OUT15/26572

**North Ryde Station Urban Activation Precinct M2 Site (SSD_5093 Mod 1)
Comment on the Response to Submissions Report**

Comment by DPI Water

Figure 4: proposed location of gas pipe relative to Porters Creek headwall and stormwater drain.

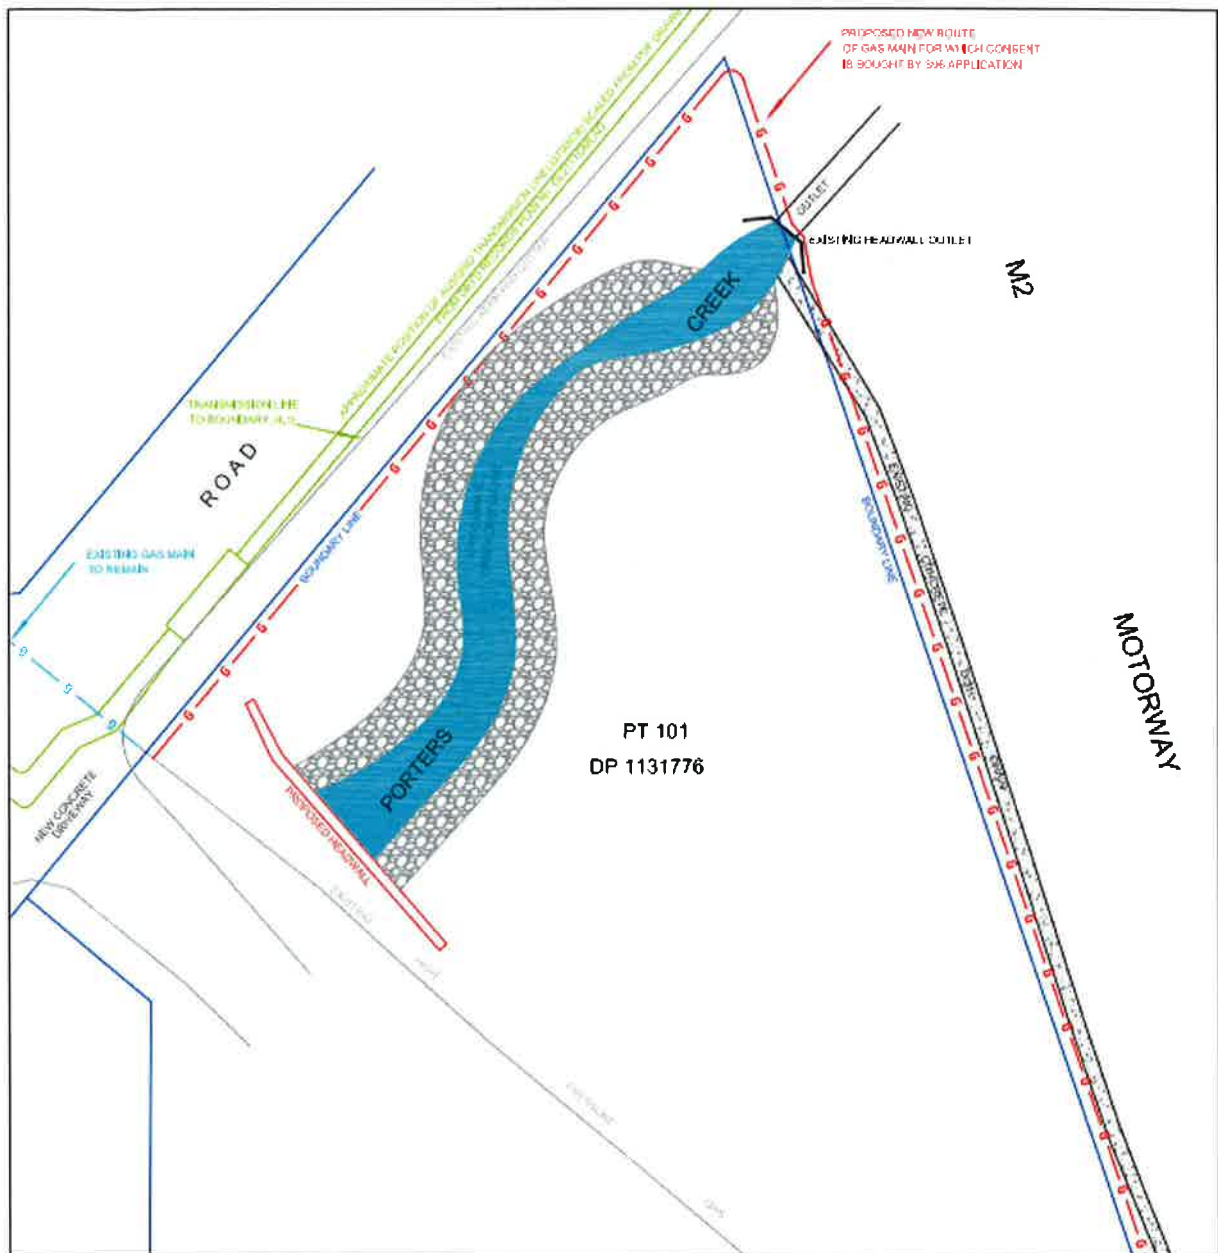
DPI Water notes the gas main crossing of Porters Creek will now be in a concrete encasement on top of the underground concrete pipe which forms the culvert into which Porters Creek flows. This modified approach avoids the need to excavate the creek bed and bank. DPI Water supports this approach to avoid impacts to Porters Creek and associated riparian vegetation.
